Your Ref 2023/92448

Proposal: Further Information: Outline application for erection of B8 industrial unit

Location: Former Cooper Bridge Water Treatment Works, Leeds Road, Huddersfield

Waterway: Calder & Hebble Navigation

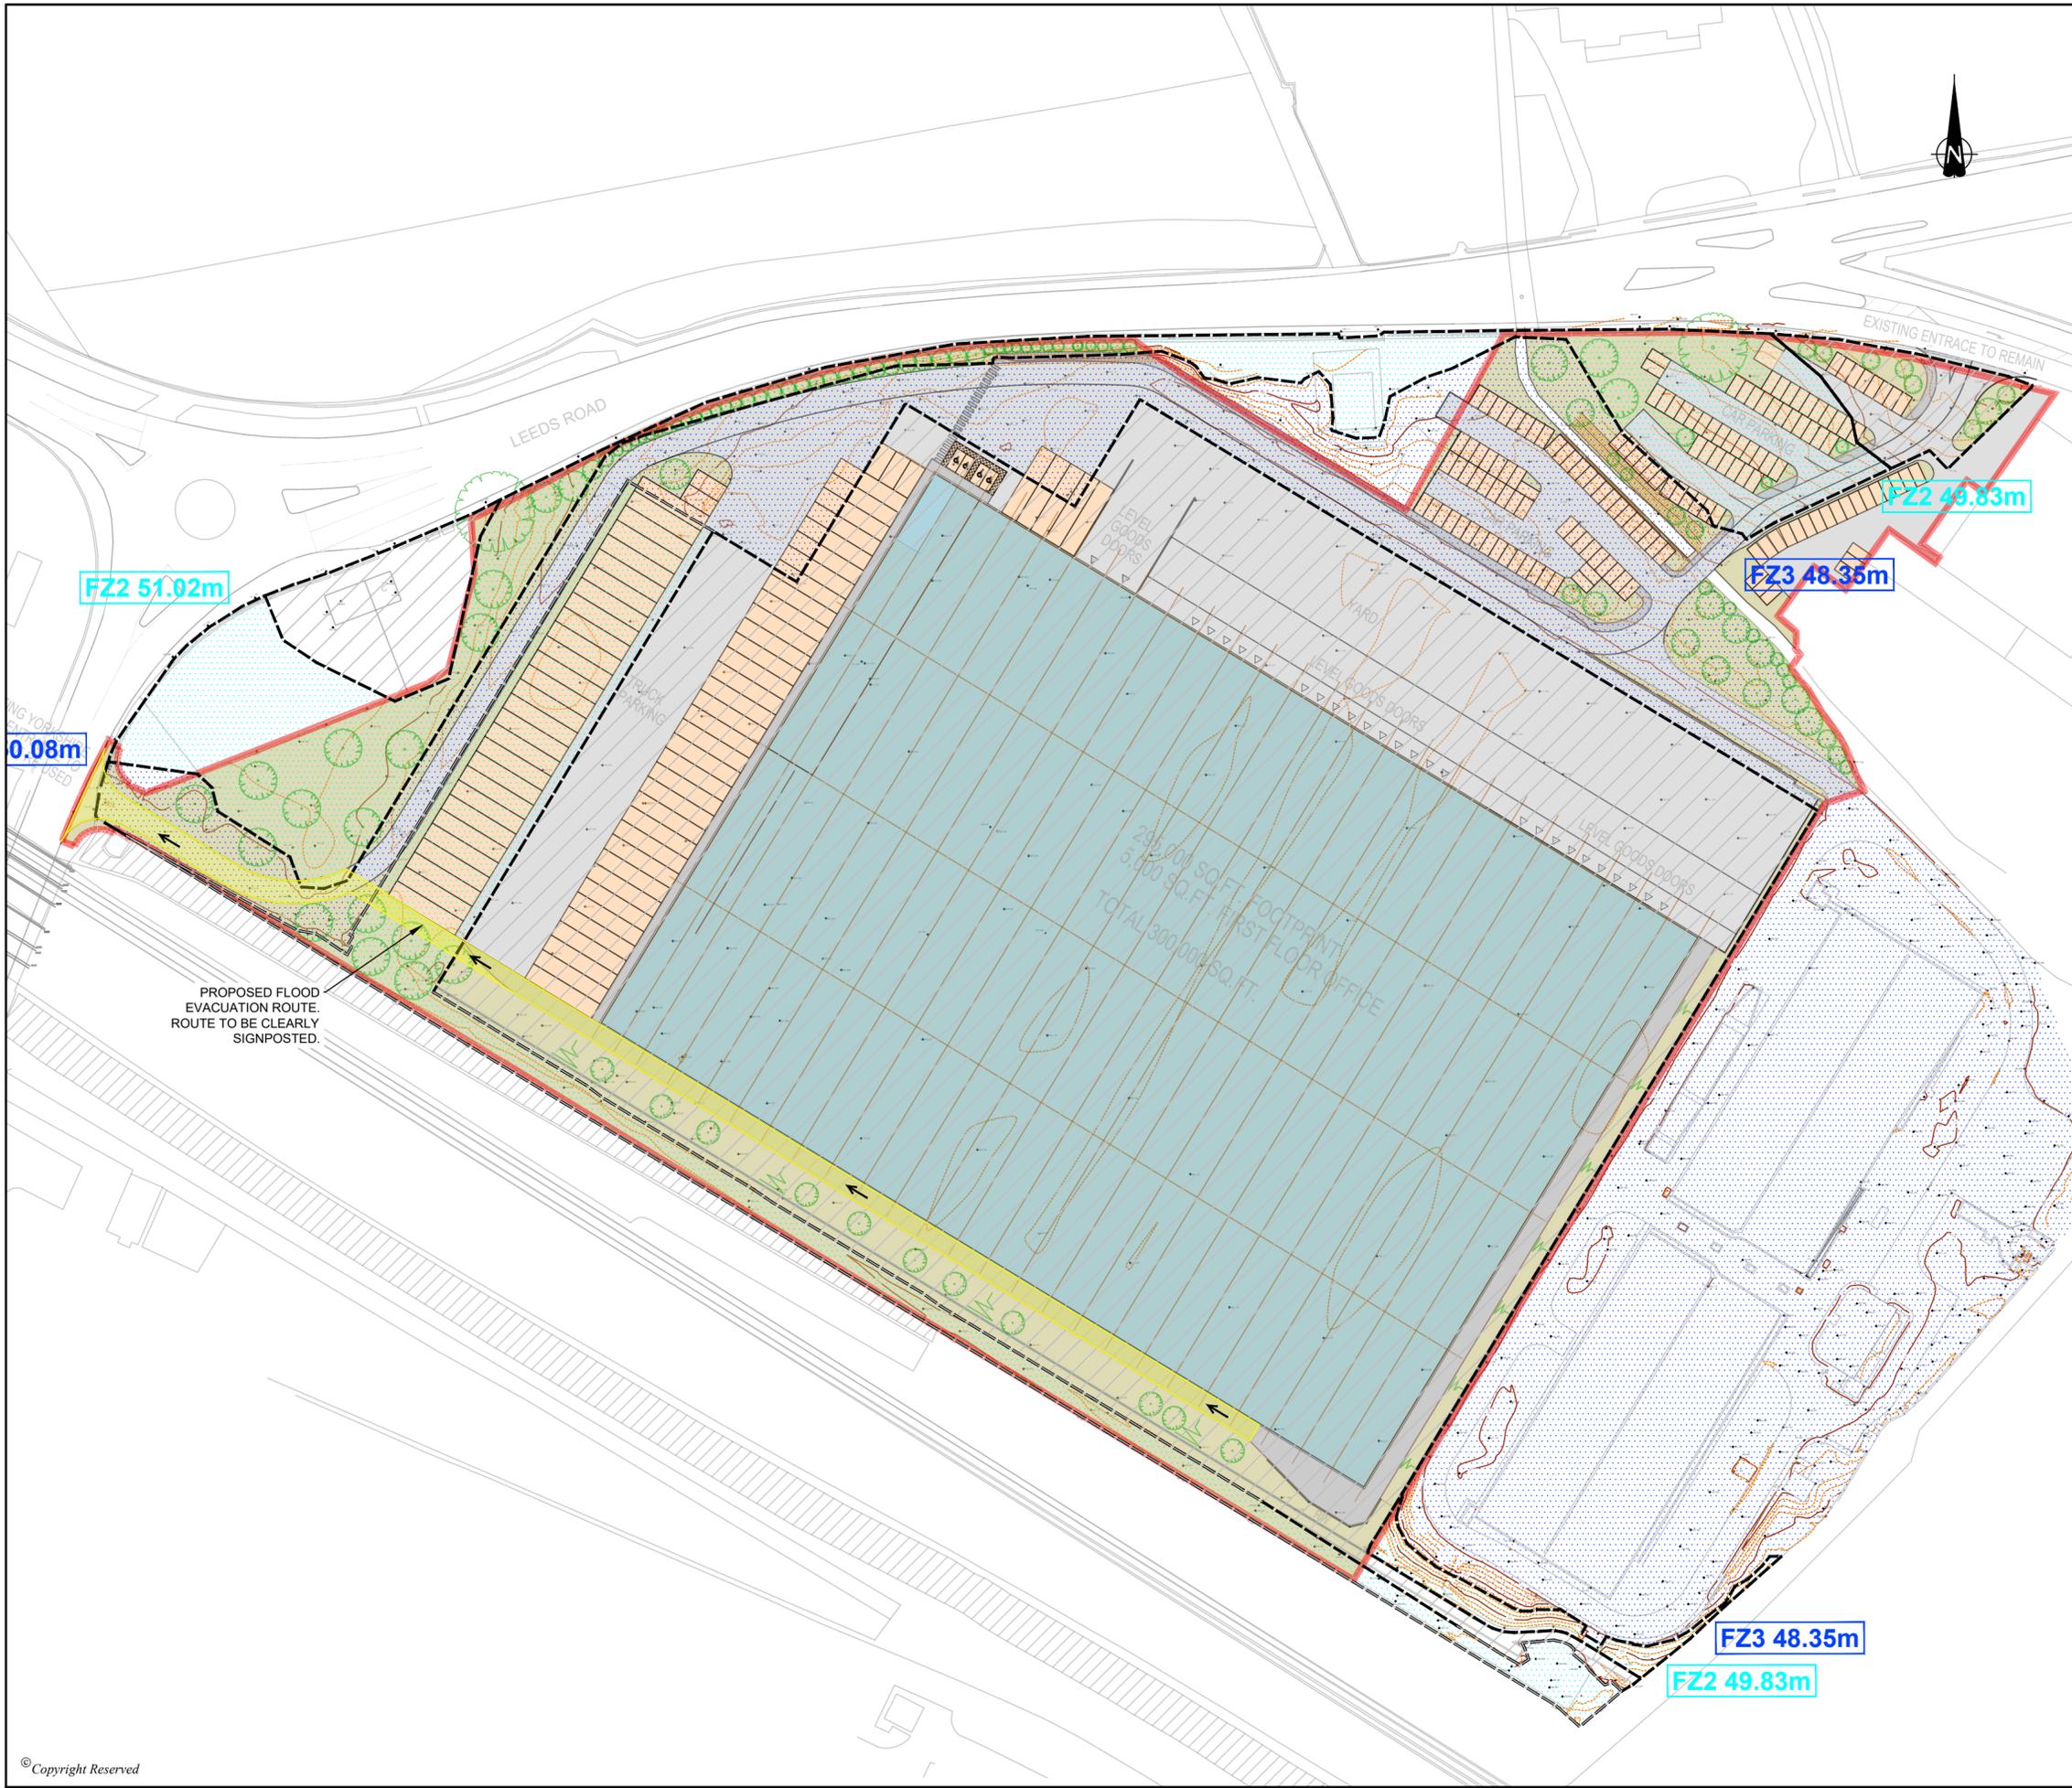
The indicative details show that surface water drainage to Nun Brook is proposed. This flows into the River Calder. We request that, prior to the commencement of development, full details of pollution interceptors (indicated on the submitted details) and a maintenance regime should be provided, so as to ensure that the discharge would not result in pollution to the water environment. This would help ensure compliance with the general aims of paragraph 180 (part e) of the NPPF concerning the protection of the water environment from pollution.

Figure 10 – Site Plan

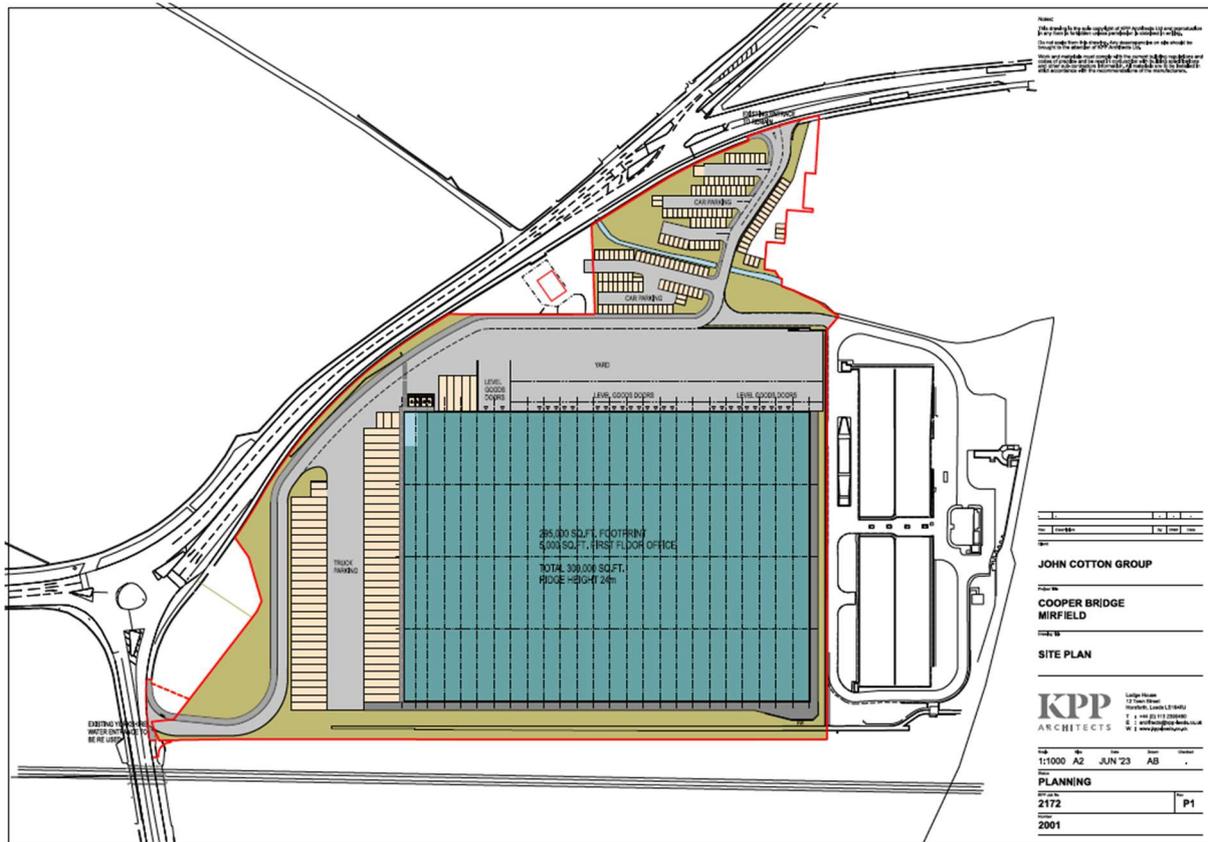
The indicative parameters plan, and the indicative site block plan, submitted with the application shows a landscaped area to the east of the new building, between the new build and retained filtration tanks. The plans show that this would not extend to encompass the width of the whole building, stopping short of the North elevation. We request that, should the scheme be developed further beyond outline stage, that the final design should seek to incorporate a landscape buffer that extends across the entire width of the building, which would

help to reduce the prominence of the building from long distance views from the river Calder, which could help retain the semi-natural character of the river corridor.
